Our ref: HMS ID 11667

Advice on Environmental Impact Statement – State Significant Development

Proposal: Oakdale East Industrial Estate, Precinct 2

Major Project reference: SSD-77020757

Figure 37. Location of OE AS1 overlaid on the Biodiversity Management Plan. The OE AS1 is located in areas where vegetation will be retained.

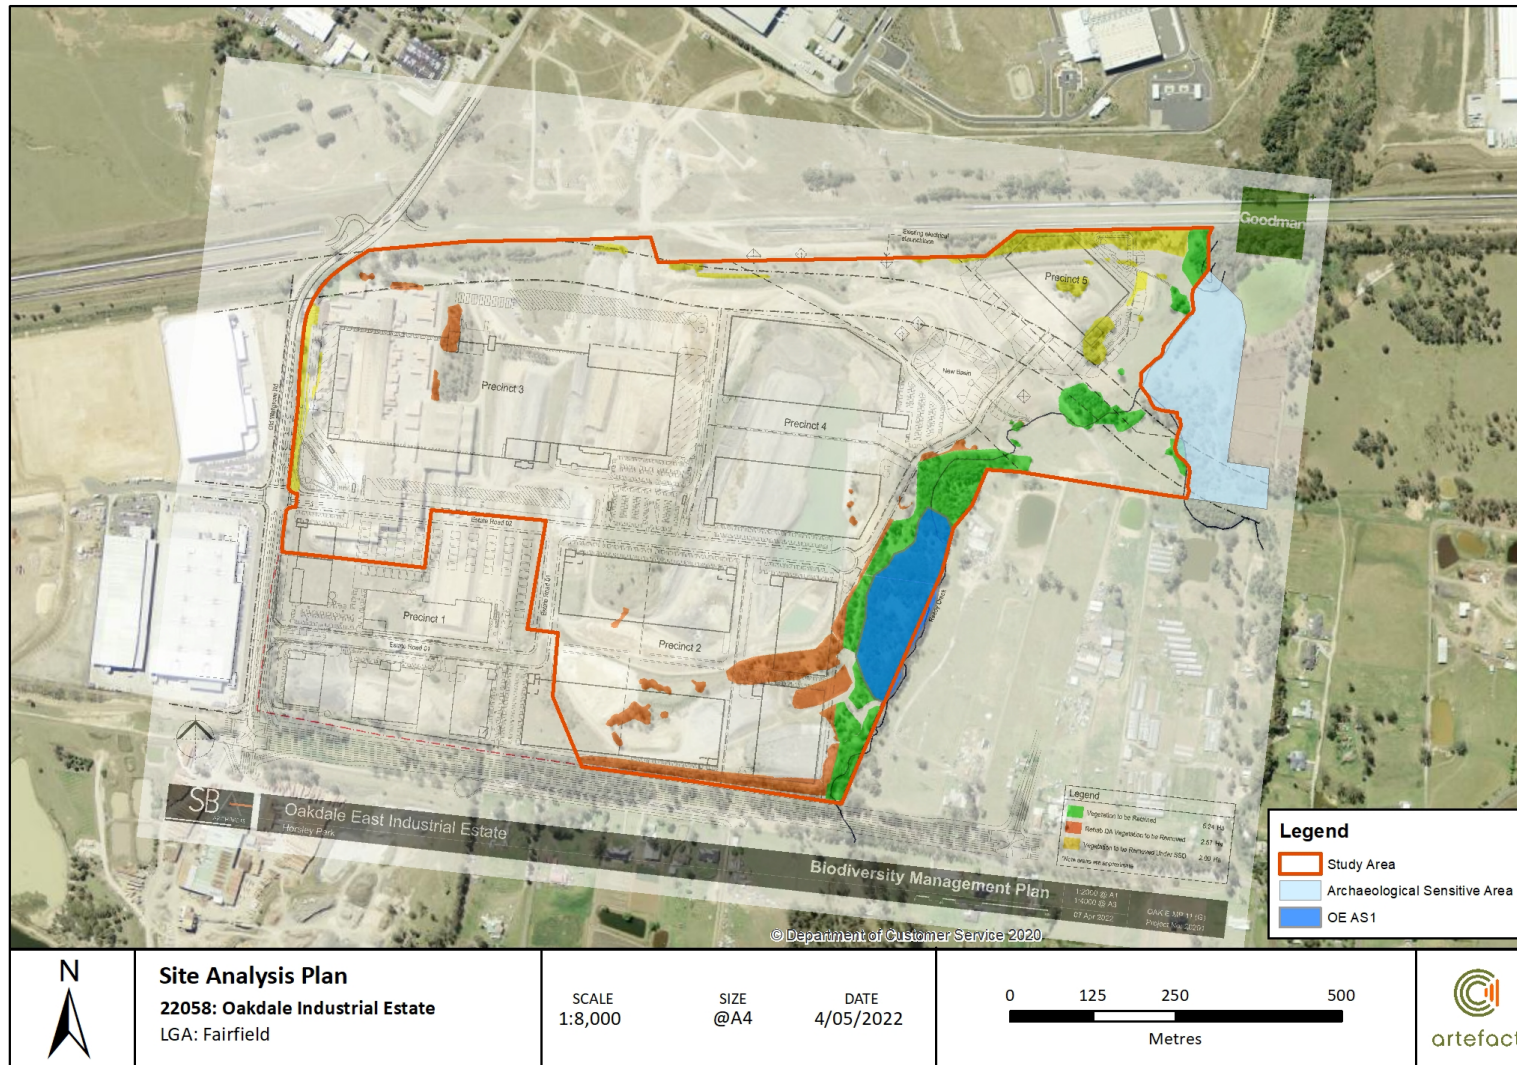
3. Considering the proximity of OE AS1 (AHIMS 45-5-5620) to the boundary of Precinct 2, it is recommended that the management measures are updated to include protective measures to prevent inadvertent harm to the site. This may include protective fencing prior to construction and/or identification of the site as a no-go area of construction mapping.
